The Secretary
NSW Department of Planning, Industry and Environment

21 November 2021

I refer to the Department's below email of 18 November 2021 regarding the Environmental Impact Statement (EIS) for State Significant Development State Significant Development SSD-25452459 First Building Bradfield City Centre for 'Construction, fitout and use of the proposed First Building as an advanced manufacturing research and development facility, including site preparation works, site access and parking, utilities infrastructure and landscaping' at 215 Badgerys Creek Road, Bringelly (Lot 10 DP 1235662) in the Liverpool City Council Local Government Area (LGA). Submissions need to be made to the Department by 16 December 2021.

Figure 38. AMRF – First Building ground floor plan (Architectural drawings prepared by Hassell, 2021).

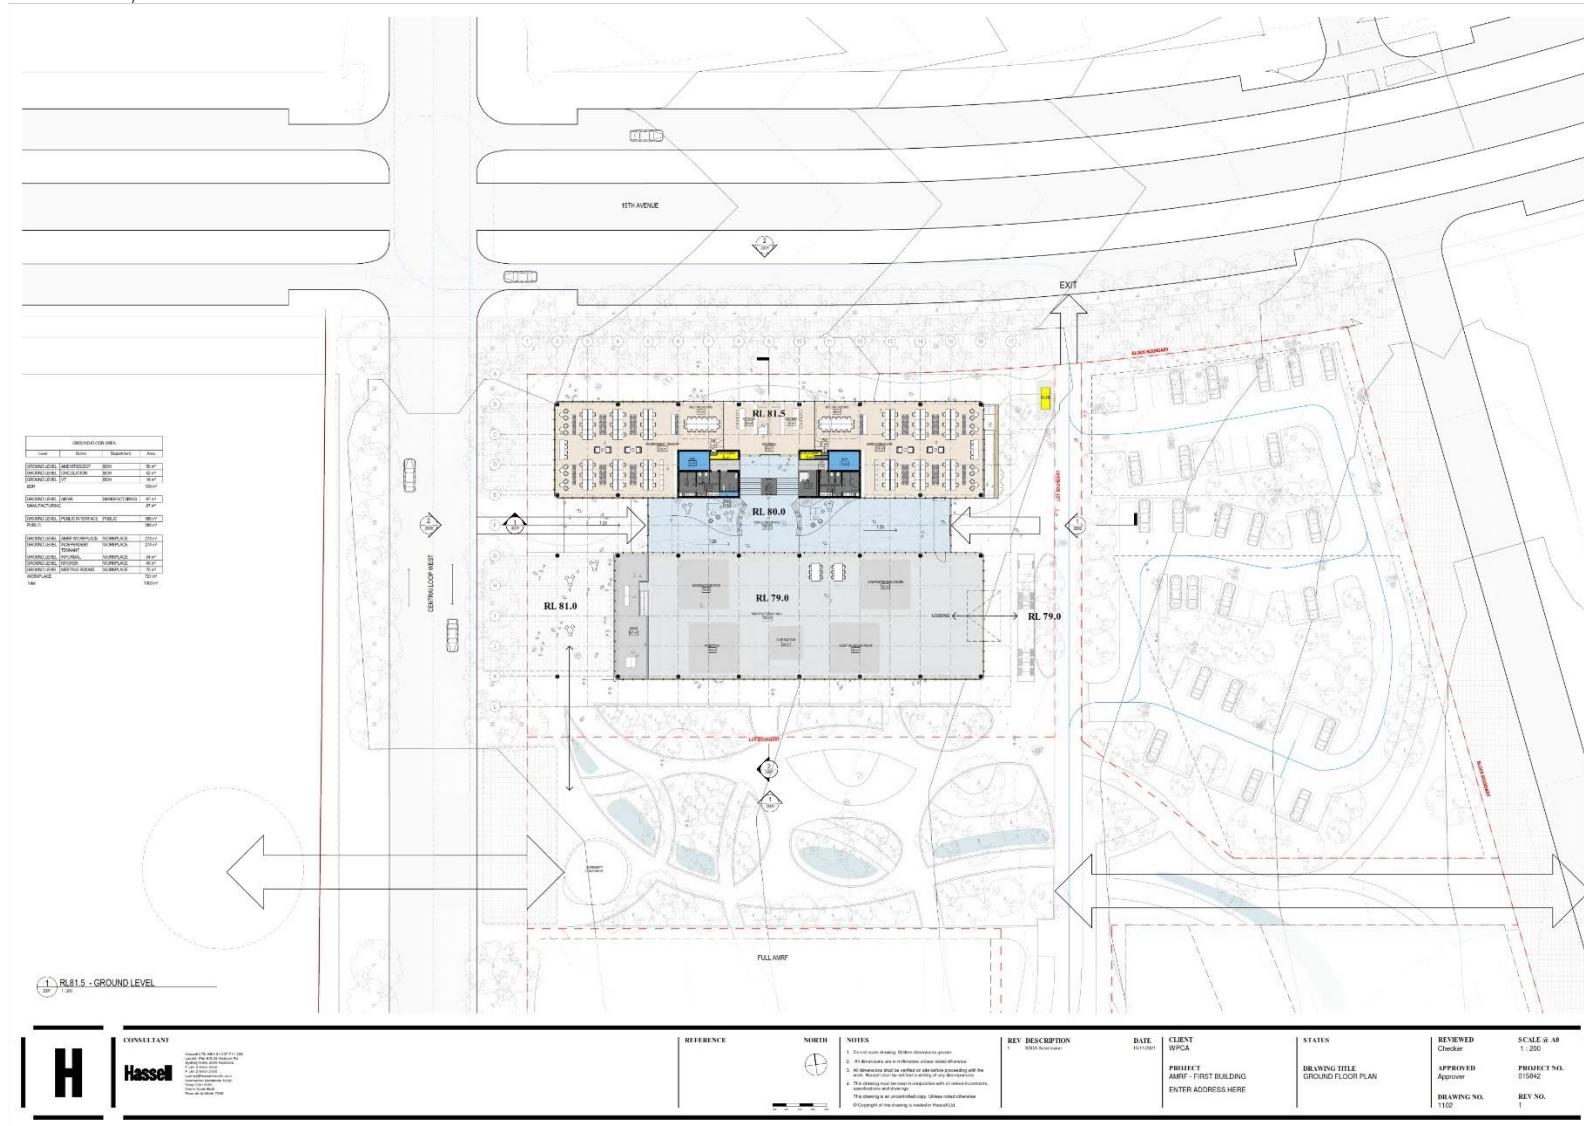
The Civil Design Report indicates a new padmount substation at property frontage within the First Building lot which is shown in the following extract of Appendix C (i) – Architectural Plans.

From Endeavour Energy's perspective the fact that provision is being made for a padmount substation is a positive. Endeavour Energy's general requirements is for a padmount substation to be at ground level and have direct access from a public street (unless provided with appropriate easements for the associated underground cables and right of access).

- Easement with a minimum size of 2.75 x 5.5 metres (single transformer).
- Restriction for fire rating which usually extends 3 metres horizontally from the base of the substation footing / plinth and 6 metres vertically from the same point.
- Restriction for swimming pools which extends 5 metres from the easement.

- Personnel access doors and fire exit doors to a building are not permitted within the fire restriction area.
- Gas mains/pipes shall not pass through the fire restriction area.
- A 10 metre clearance distance shall be maintained between substation and fire hydrants, booster valves, and the like in accordance with AS2419.1 'Fire hydrant installations System design, installation and commissioning' as updated from time to time.
- Any landscaping that potentially could transfer / provide connectivity for flame or radiant heat from a fire in the substation to a dwelling or building should be avoided.

Distribution substations should not be subject to flood inundation or stormwater runoff ie. the padmount substation cubicles are weatherproof not flood proof and the cable pits whilst designed to be self-draining should not be subject to excessive ingress of water. Section 7 'Substation and switching stations' of Endeavour Energy's Mains Construction Instruction MCI 0006 'Underground distribution construction standards manual' provides the following details of the requirements for flooding and drainage in new padmount substation locations.

As a minimum the level at the top of the transformer footing, HV and LV switchgear, shall not be lower than the 1:100 year flood level.

Screening vegetation around a padmount substation should be planted a minimum distance of 800mm plus half of the mature canopy width from the substation easement and have shallow / non-invasive roots. This is to avoid trees growing over the easement as falling branches may damage the cubicle and the electricity infrastructure as do tree roots. All vegetation is to be maintained in such a manner that it will allow unrestricted access by electrical workers to the substation easement all times.
